**FIRLOUGH WIND FARM, CO. MAYO
AND
HYDROGEN PLANT, CO. SLIGO**

**SECOND RESPONSE TO THIRD PARTY
SUBMISSIONS
AND OBSERVATIONS
PLANNING APPLICATION REFERENCE
ABP-317560-23**

PROJECT	Firlough Wind Farm and Hydrogen Plant	
CLIENT / JOB NO	Mercury Renewables (Carrowleagh) Limited	6129
DOCUMENT TITLE	Second Response to Submissions Received

Figure 11.9 Noise Contour Map for Hydrogen Plant

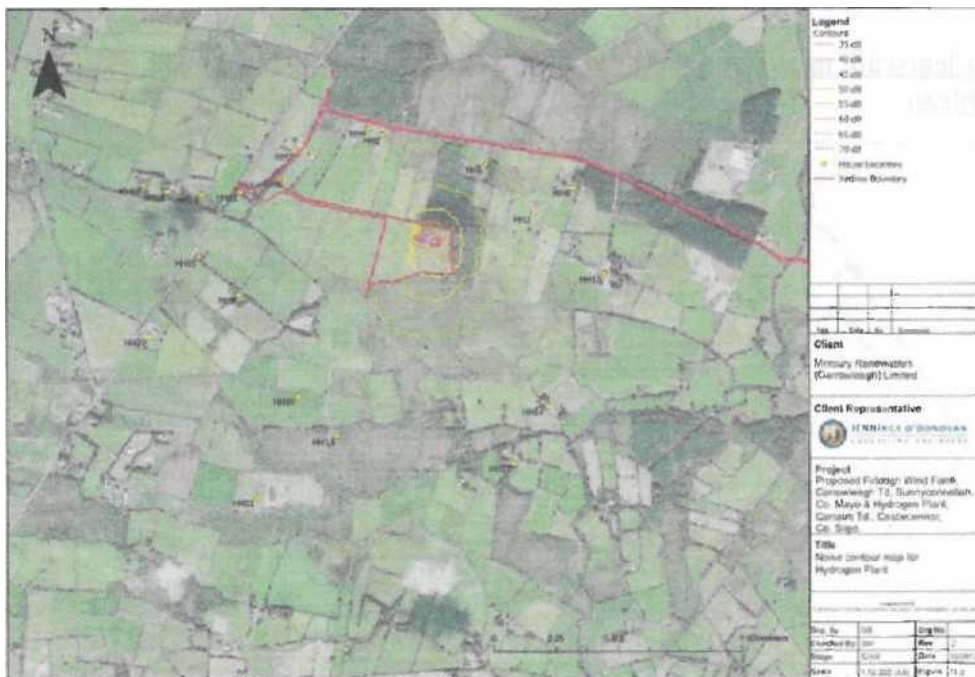
In the intervening period since the application was submitted, it has become apparent that a minor error in the location of two derelict and disused house locations was made in Figure 1.3; Hydrogen Plant Site House Locations and in Figure 11.9; Noise Contour Map for Hydrogen Plant.

House numbers HH10 and HH13 have been mapped in error approximately 500m west of their correct location. This does not affect the technical assessments. These are both derelict houses and the corrected locations are further from the Hydrogen Plant than the location assessed in Chapter 11 Noise. The noise impacts would therefore be expected to be slightly lower than those identified. The derelict house locations are both well outside the noise contours.

- HH10 was mapped as 600m to the southwest of the Hydrogen Plant, the correct location is 610m to the southeast of the Hydrogen Plant.
- HH13 was mapped 680m to the southwest of the Hydrogen Plant, the correct location is 830m to the southeast of the Hydrogen Plant.

For the avoidance of doubt Figure 1.3 and Figure 11.9 of the EIAR has been updated to include the corrected location of these two derelict houses.
